From: Laura Gibbons <Laura.Gibbons@arun.gov.uk>
Sent: 27 April 2021 10:45
To: Planning.Responses <Planning.Responses@arun.gov.uk>
Cc: Michael Eastham <Michael.Eastham@arun.gov.uk>
Subject: FP/248/20/PL- Land north of Felpham

Thank you for consulting us on this application. We have the following comments on flood risk and surface water drainage.

Drawing Title:
CHANGING FACILITIES BUILDING
SITE LAYOUT

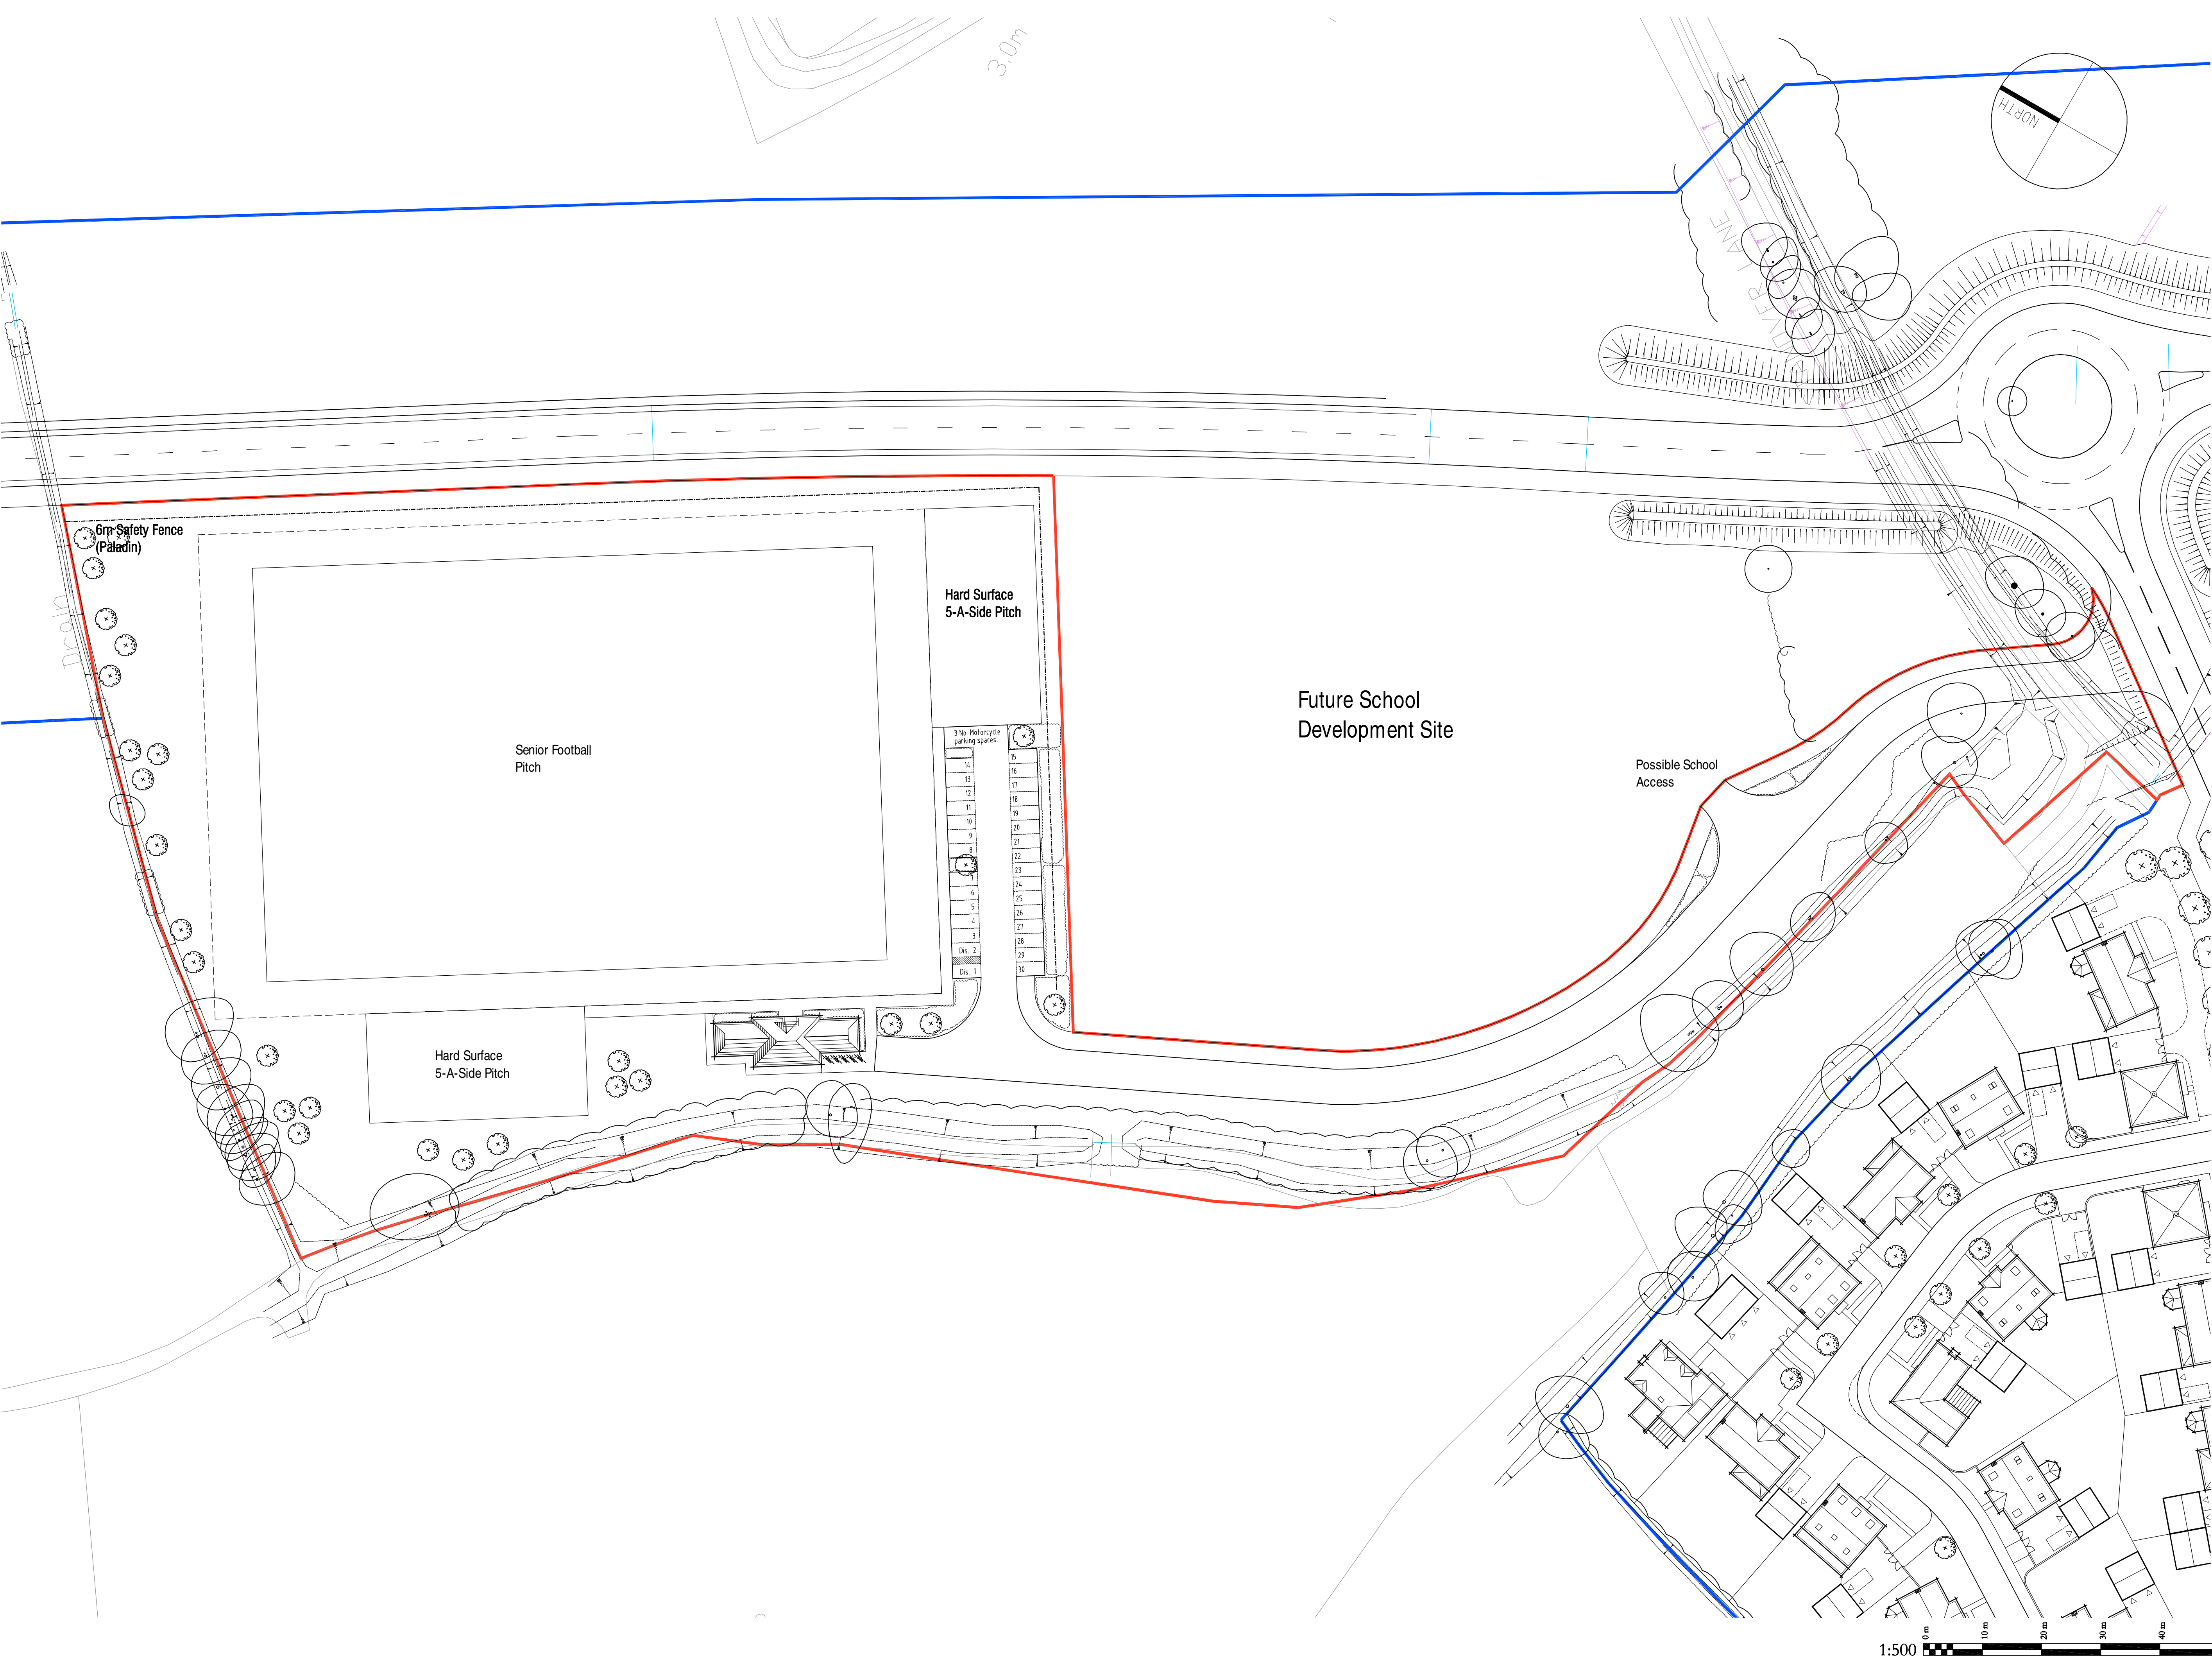
The proposed site plan shows that some structures are in very close proximity to the existing ordinary watercourses which run along the southern and eastern boundaries. A buffer plan should be submitted evidencing that there is at least 3m between the top of bank of watercourse and structures which will restrict access for maintenance. A lot of the proposed SuDS features are shown in very close proximity to the watercourse. A 3m buffer must also be provided around the top of bank of swales and attenuation features.

The proposed discharge location for surface water goes against the direction of flow in the watercourse. The calculations included within the flood risk assessment do not apply a surcharged outfall. This should be applied at detailed design to ensure there is adequate storage capacity on site when the water levels in the watercourse are high.

We would request that information regarding easement to watercourses is provided prior to determination.
